**Planning Application, Ribble Valley District
3/11/05611 land at Blue Trees, Copster Green, Salesbury**

I am recommending refusal of this application on highway safety grounds.

drawing title:
 PROPOSED SITE PLAN

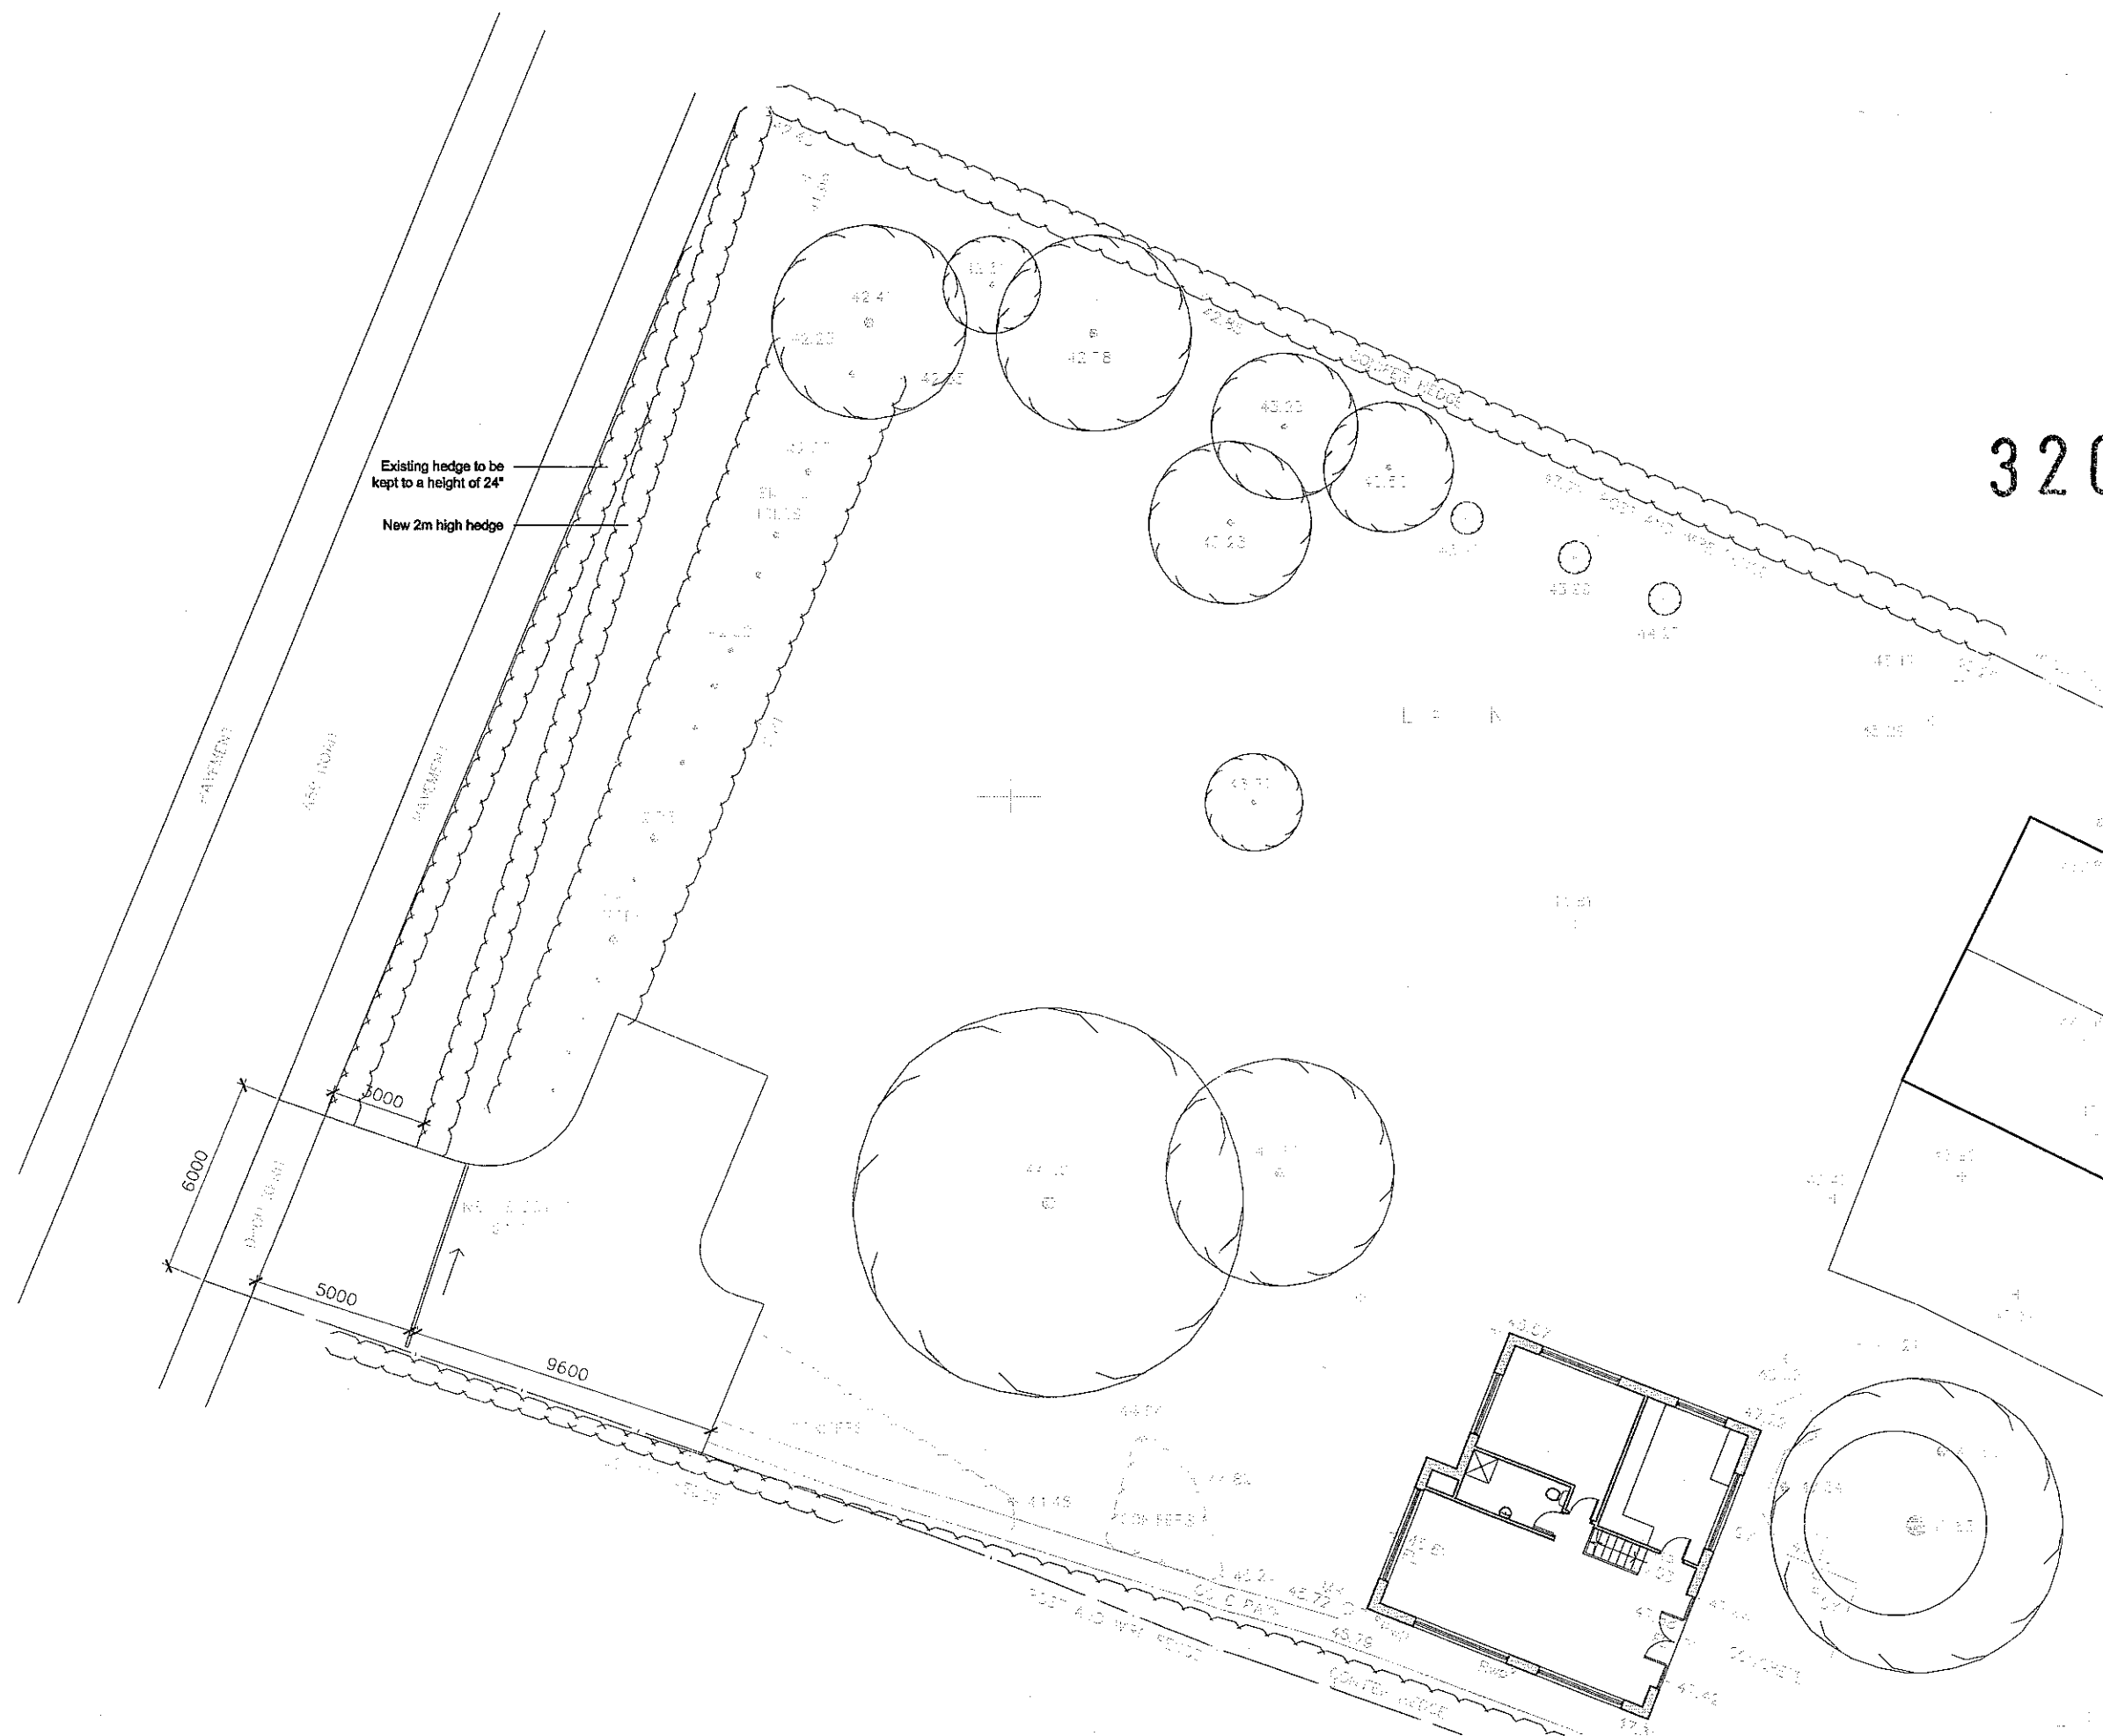
For a heavily trafficked road of this type with a 40mph Speed Limit I would require a new access point onto the highway to provide a 2.4 metre x 90 metre visibility splay in both directions, as recommended in Manual for Streets 2 and the Design Manual for Roads and Bridges.

The best visibility splay the applicant can realistically achieve to the east, the more critical of the two directions, is around 2.4 metres x 60 metres. This is significantly below what would be acceptable.

The Applicant has located the proposed new access immediately adjacent to the westerly boundary of his site. While this has maximised the easterly sightline, it has had a highly detrimental impact on the potential sightline to the west.

As there is work ongoing at the neighbouring property, it is not possible to provide a definitive indication of the available visibility. However, it is clear that the Applicant has no control over any third party land to the back of the public highway. The footway is approximately 1.6m wide at this point and it is only within that distance back from the carriageway edge that I can realistically assess the available sightline.

On this basis, the maximum visibility splay that can be achieved is 2.4m by 21m. This is allowing for an advantageous measurement taken to the centre of the carriageway due to the proximity of the pedestrian refuge to the west that provides a physical restriction on overtaking manoeuvres.

I therefore recommend a refusal of the application on highway safety grounds.
